Dean Moor Solar Farm – Applicant response to S51 Advice

Application Ref: EN010155

DEAN MOOR SOLAR FARM
DEVELOPMENT CONSENT ORDER
REGULATION 5(2)(K)
Streets and Access Plans
Version 2

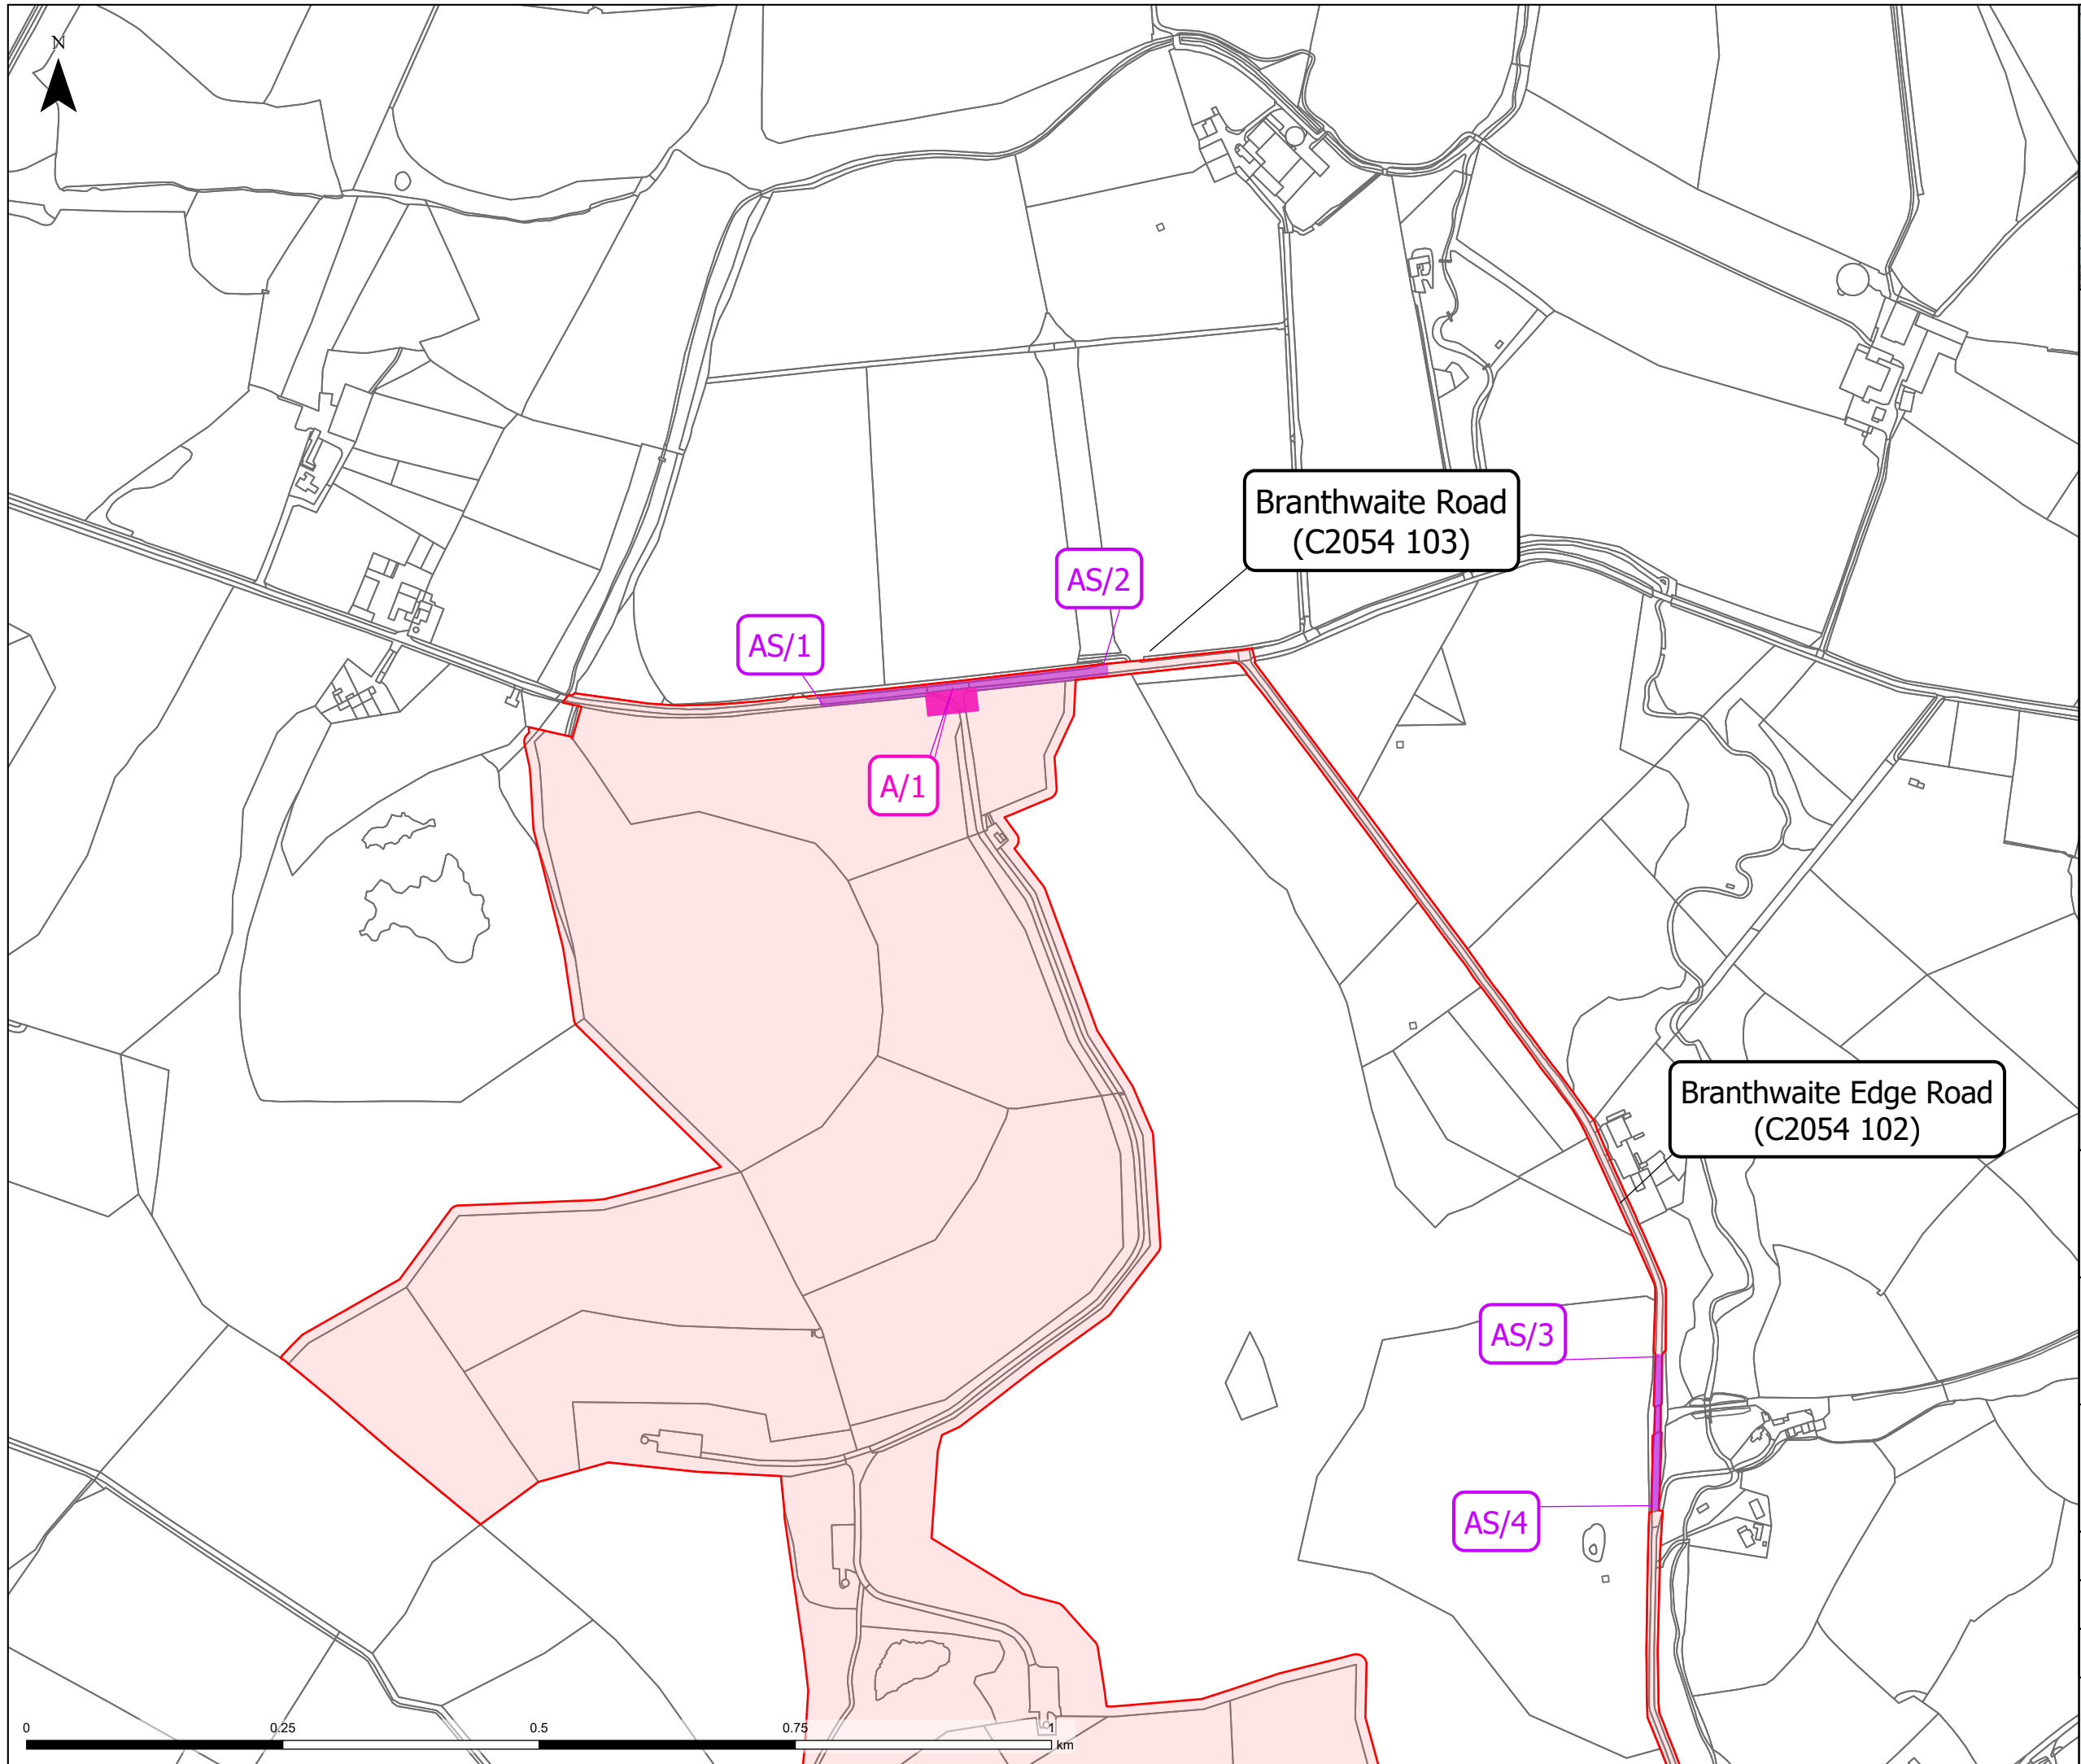
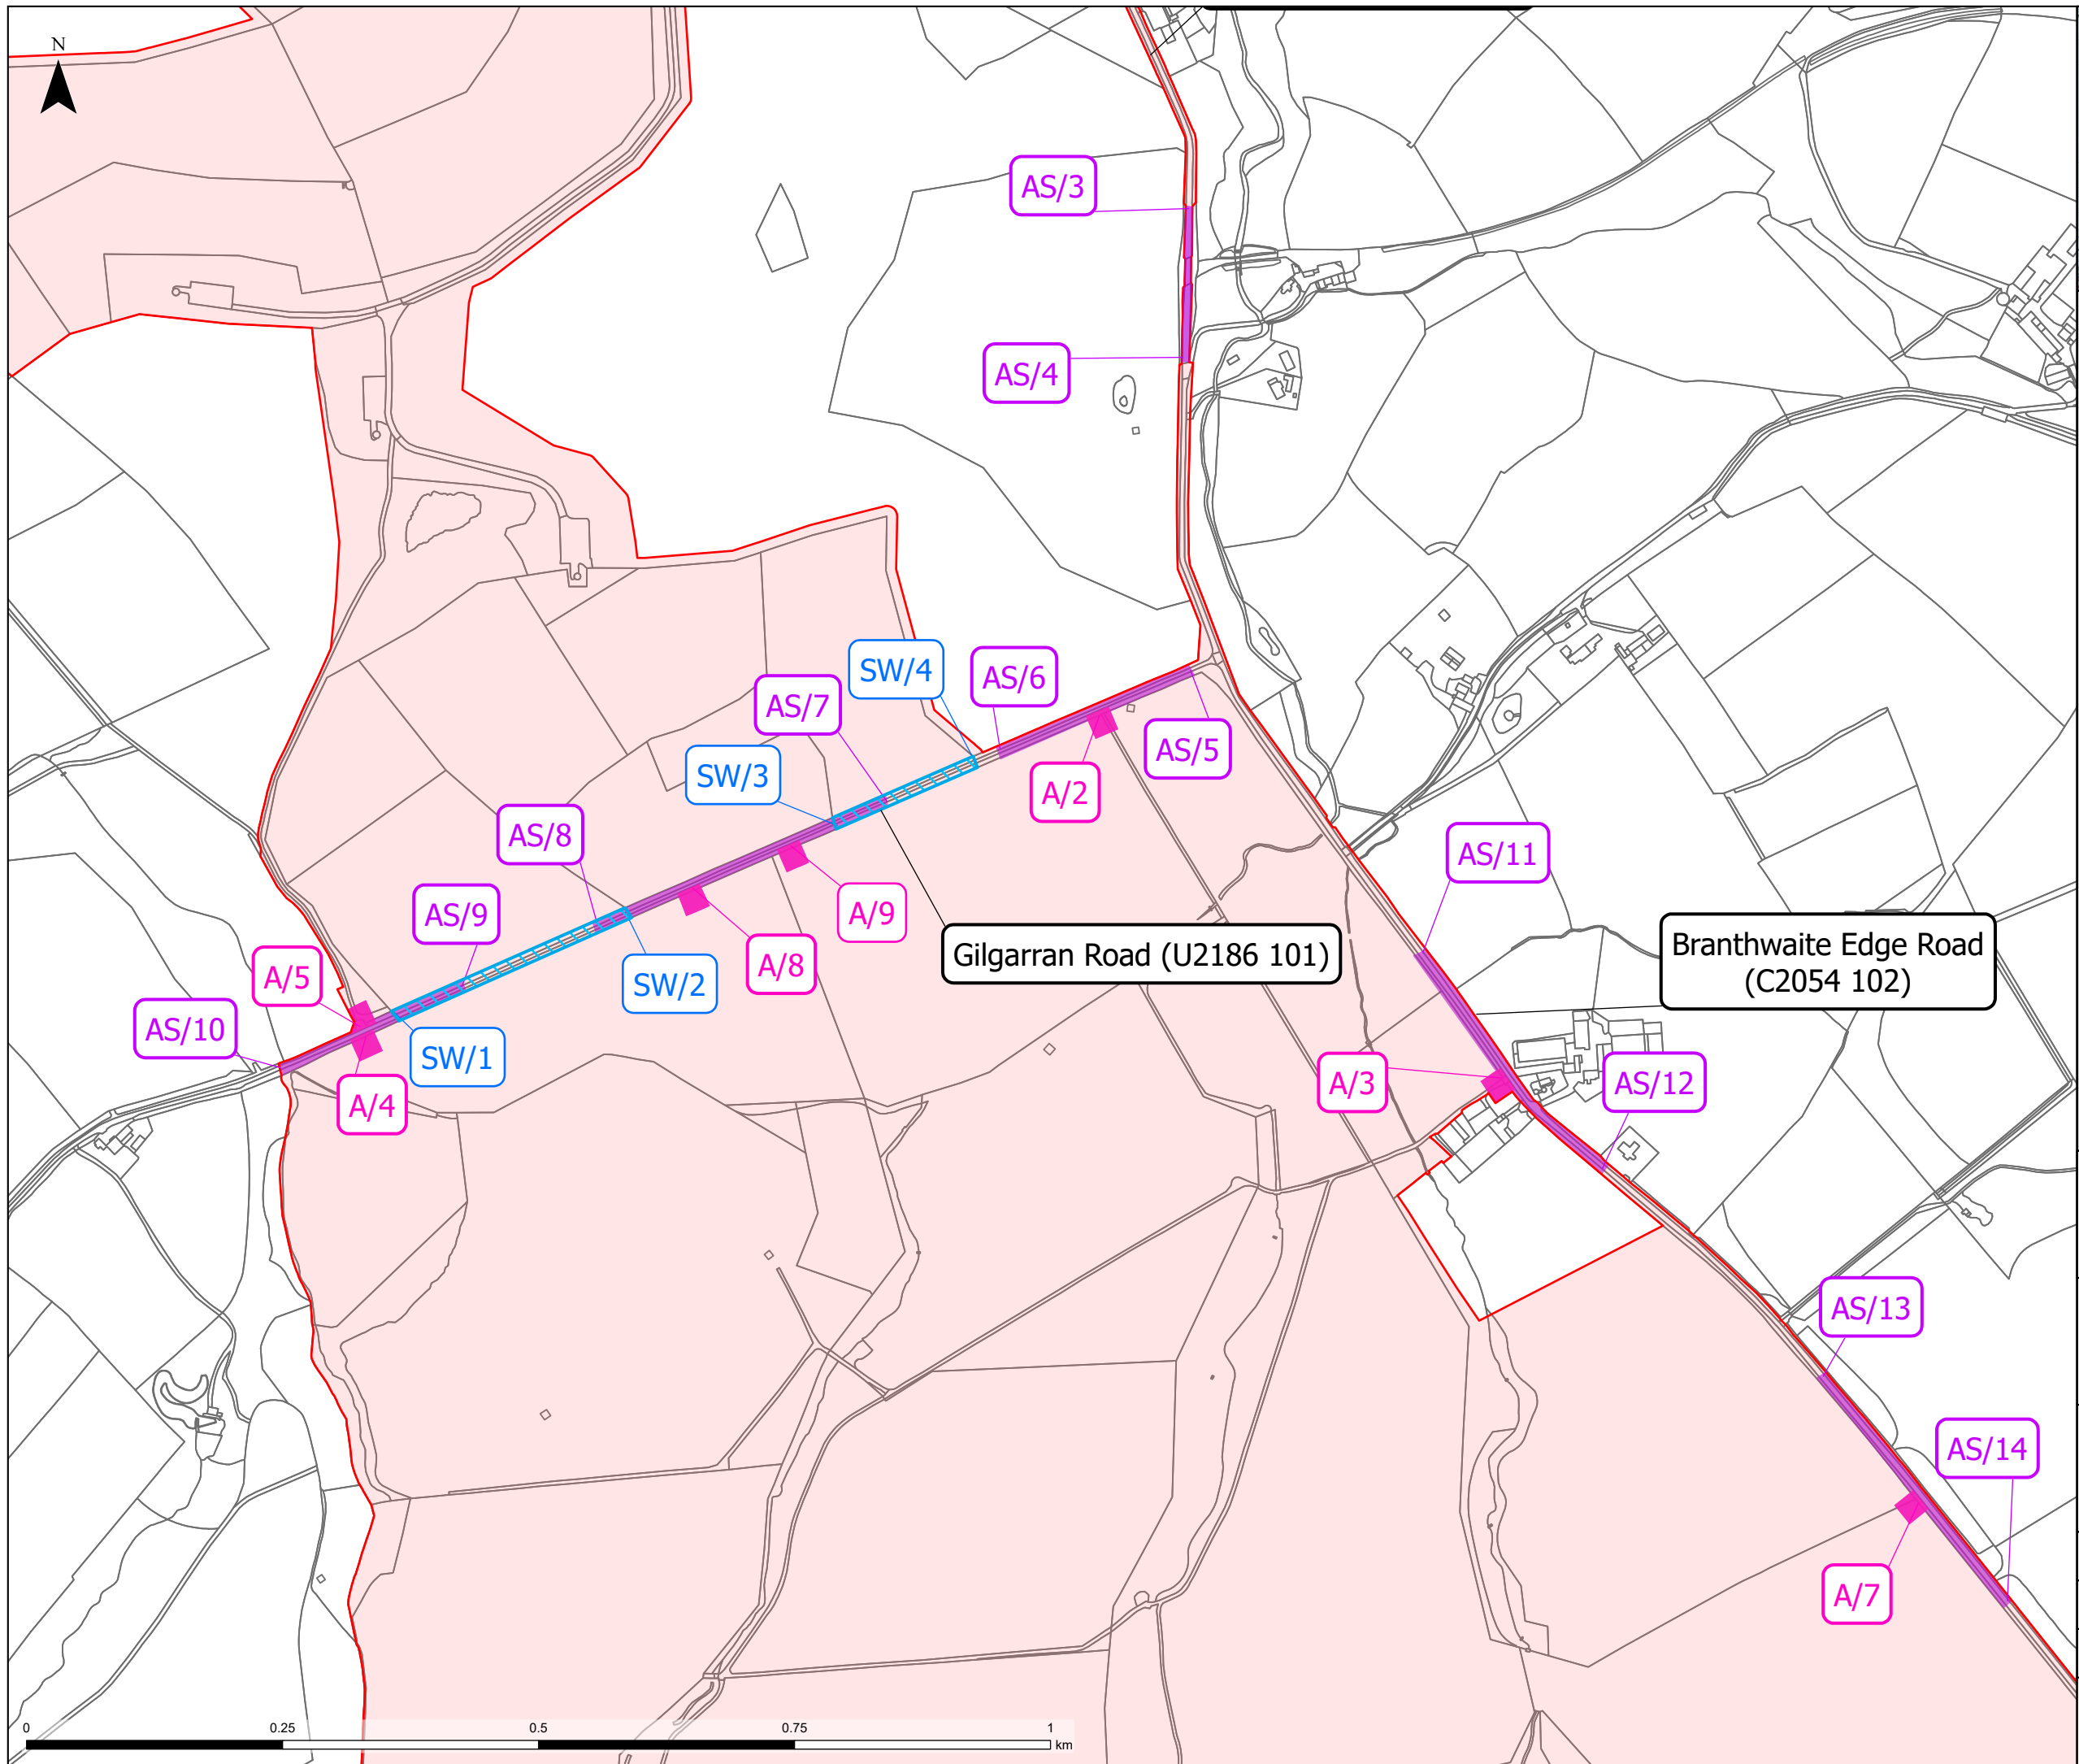
3	Streets and Access Plans (Doc 2.4)	The plans do not have any road names as identified in the dDCO.		The Street Works and Access Plans [APP-006] have been updated accordingly and are included with this response.
4	Traffic Regulation Measures Plan (Doc 2.5)	The plan does not have any road names as identified in the dDCO. Schedule 6 of the dDCO states points TSC/1 and TSC/2 hatched yellow on the plan, but the colour on the plan is orange.		The Traffic Regulation Measures Plan has been updated accordingly. The changes include: <ul style="list-style-type: none"> ▪ Adding the road names identified in the dDCO; and ▪ Changing the colour on the plan to yellow so that it reflects the wording in Schedule 6 of the dDCO. The updated plan is included with this response, this would supersede the originally submitted version of the Plan [APP-009] .
5	Consultation report (Doc 5.1)	The Applicant has provided a list of persons consulted under s42(1)(a) on 9 March 2024 at Appendix 5.1, however elsewhere in Appendix 4.7 the Applicant refers to a definitive list of consultees who were actively consulted in Appendix 3.9. We were unable to locate Appendix 3.9 within the submitted application documents. If this appendix is missing, we request this to be submitted before the Relevant Representation period opens.		Please note that reference to Appendix 3.9 is incorrect and that all stakeholders consulted under s42(1)(a) are captured in Appendix 5.1. The Consultation Report has been updated to reflect this. This was issued to the Planning Inspectorate on 07/05/2025 [AS-001] .
